Development Facilitation Team (DFT) – Review Comments

Project No: PR-2023-008674 Date: 05/08/2024 Agenda Item: #4 Zone Atlas Page: H-11

Request: Subdivision of Land – Preliminary Plat for Playa Del Sur

Application For: SD-2024-000056-Preliminary Plat

**Plat for
Playa Del Sur
Being Comprised of
Portions of Tracts 308, 309 and
310, Unit 8, Town of Atrisco Grant
City of Albuquerque
Bernalillo County, New Mexico
January 2024**

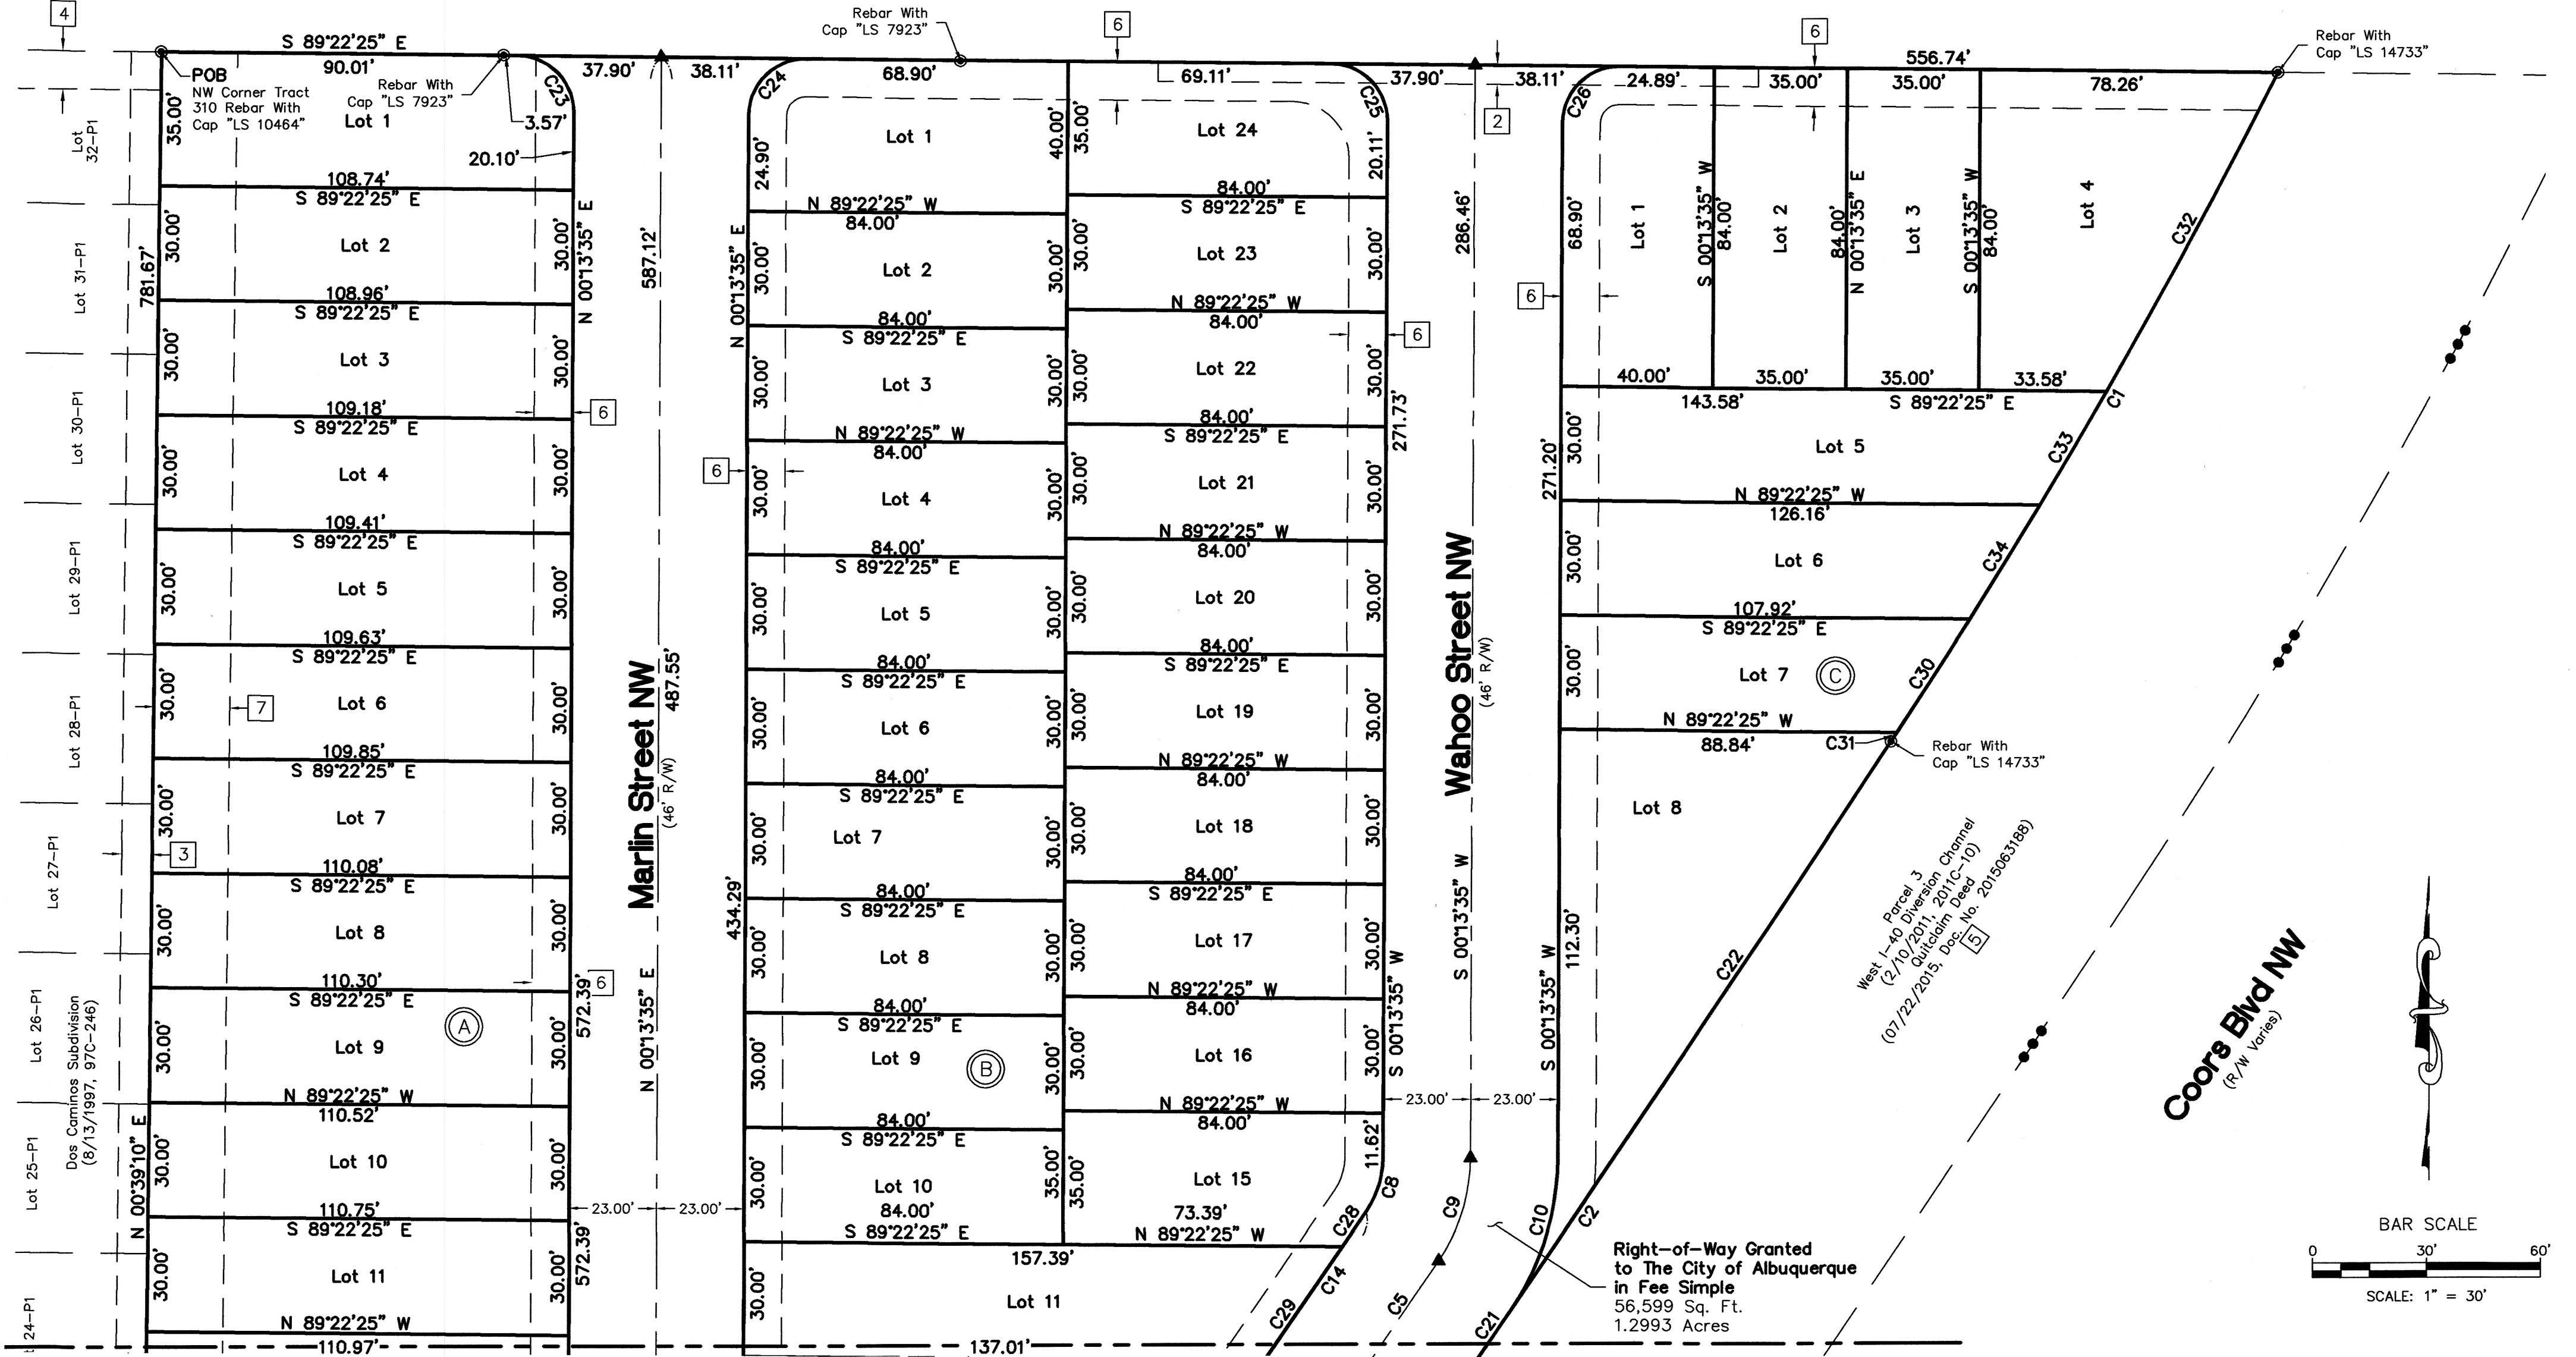
The applicant has discussed the following as mitigation measures: a perimeter wall all along the east property boundary. A continuous, opaque 8 foot CMU wall, not narrower than 6-inches, and with a variegated surface, possibly split-face faced block along the eastern property line and parallel to the I-40 onramps, is required to achieve public health in this area.

- (1) The **northeast corner of the site be redesigned** with a stub street so that no home faces Miami near Coors;
- (2) OR that the eastern perimeter **wall wrap around the northeast corner continuing 35-50 feet along Miami. The wrap around on the front yard would require a variance.** Without the wrap around wall, staff requests that additional noise readings be done during the entire peak period (not just 5:30 to 6:00 am) to see the exact mitigation measure, including wall design, that is needed for homes that would front on Miami. See figure below (8 foot CMU wall is shown in red):

- The perimeter wall design must be on a plat sheet that accompanies the plat and is approved with the plat to guide later stages of development when the perimeter walls are built. The following note must be added to the Plat: **“The developer of the subdivision is responsible for building noise walls and using building façade treatments to attenuate the traffic noise from the adjacent on ramps to I-40 West and Coors Boulevard.”**
- Confirm that all lots have a depth sufficient to allow a 20-foot driveway from garage to sidewalk beginning, with no sidewalk encroachment per IDO 5-3 below:

Figure 5: Noise Levels Heat Map

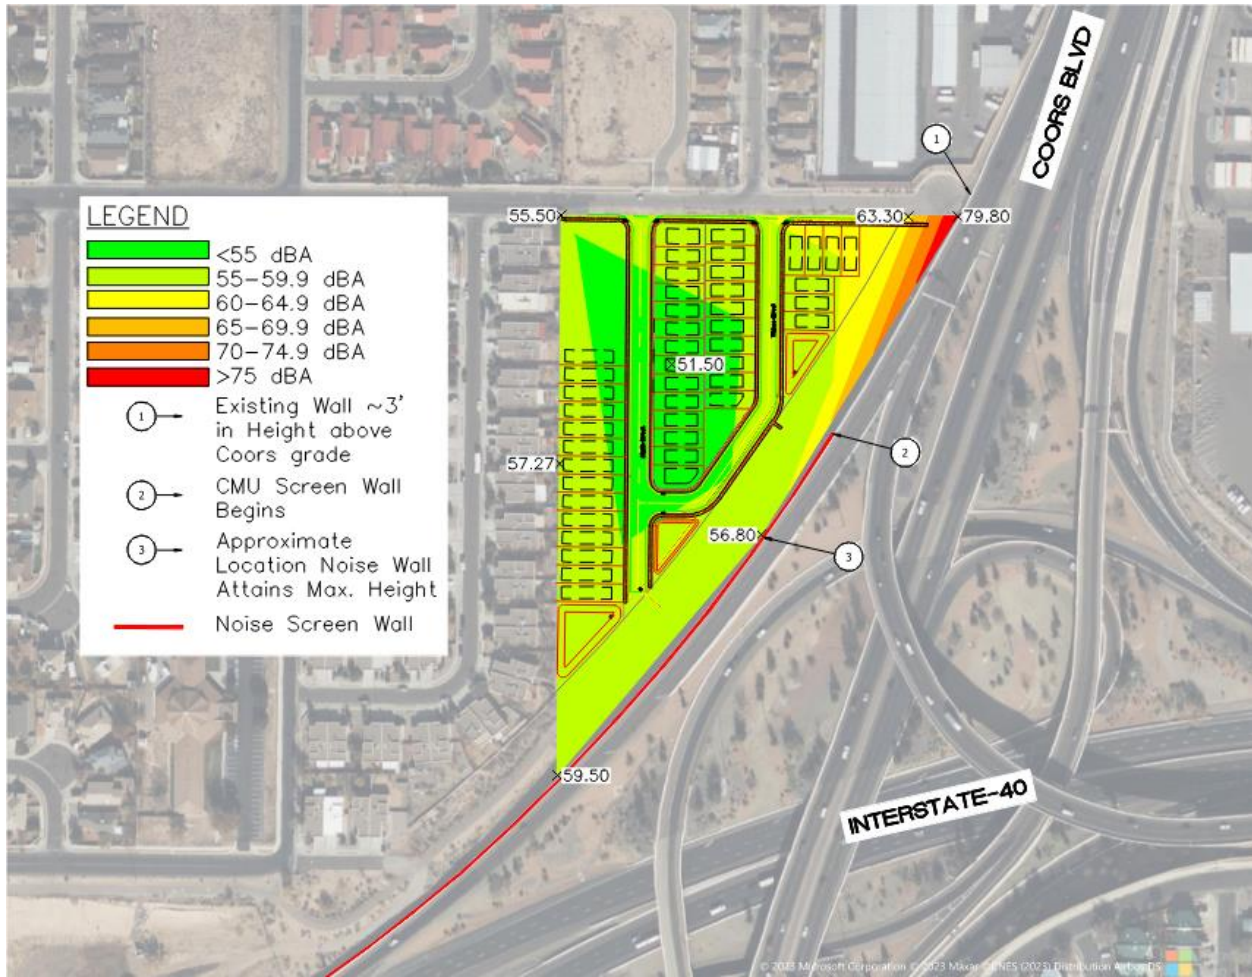
- The applicant completed a noise study because the parcels are in the northwest quadrant of Interstate 40 (I-40) West and Coors Blvd. which carries substantial traffic and generates substantial noise. The outcome of the study was that noise greater than 65 decibels is now present during the morning peak hour in the northeast portion of the site; other areas of the property had readings below 65 decibels. The noise study did not give readings for each location for the entire peak hour period.

- Planning staff have reviewed the Noise Study Report submitted as part of the Preliminary Plat application submittal, and additional noise readings/measurements may be needed in the locations noted in the exhibit below (1-3 in priority order).
